# Submissions Report

SSD-74670720

38-42 Anderson, 3 McIntosh and 2 Day  
Streets, Chatswood

FIGURE 18
SIGHT DISTANCE FOR EXITING VEHICLES

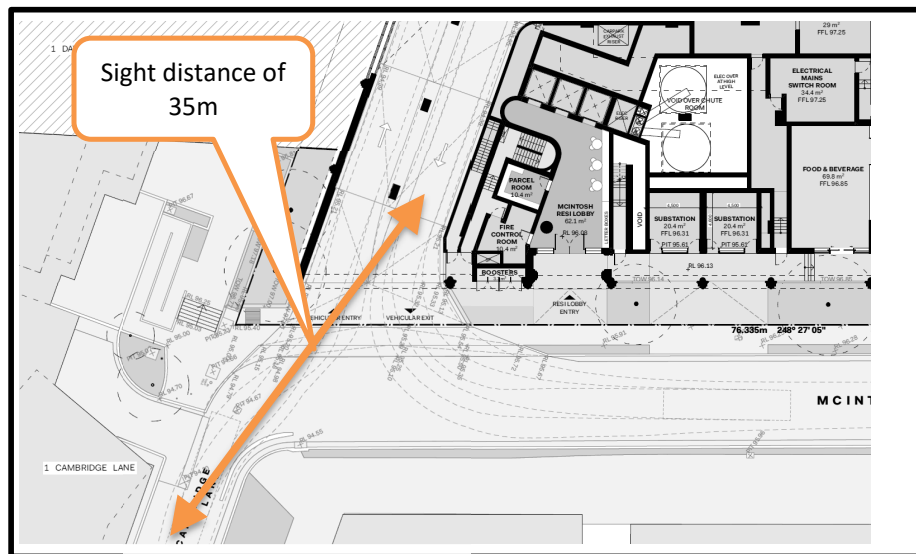
WCC-4.2	<p><b>Vehicular Access</b></p>	<p>Please refer to Appendix 5 of the TIA Sheet 8 of 17 to see the location of the splay which meets the requirements of AS2890.1:2004.</p>

ITEM REFERENCE	SUMMARY OF ISSUE RAISED	RESPONSE
	<p>The recommended sight lines stated in AS2890.2:2018 are required to be dimensioned on driveway drawings at the vehicular access. In order to ensure minimum sight distances in accordance with AS/NZS 2890.1 Figure 3.3, a minimum clear splay of 2m x 2.5m on both sides of the driveway exit is to be provided to ensure vehicle and pedestrian safety. Due to the pedestrian path immediately adjacent to the building and vehicle exit, details must be provided to demonstrate how the sight distance to pedestrians will be achieved. Council does not support the use of mirrors to achieve this where the path is in the road reserve.</p>	<p>The traffic engineer has confirmed that a splay is not required on the entry side of a two-way driveway as per the requirements of Figure 3.3 of AS2890.1:2004.</p> <p>While it is acknowledged that Figure 3.4 of AS2890.2:2018 nominates a sightline triangle on both sides of the access driveway, this is predicated on vehicles being able to use the full width of the site access driveway, which is not required at the proposed development.</p> <p>Accordingly, a sightline triangle only on the departure side of the driveway is considered necessary and no changes are required to the proposed design.</p>
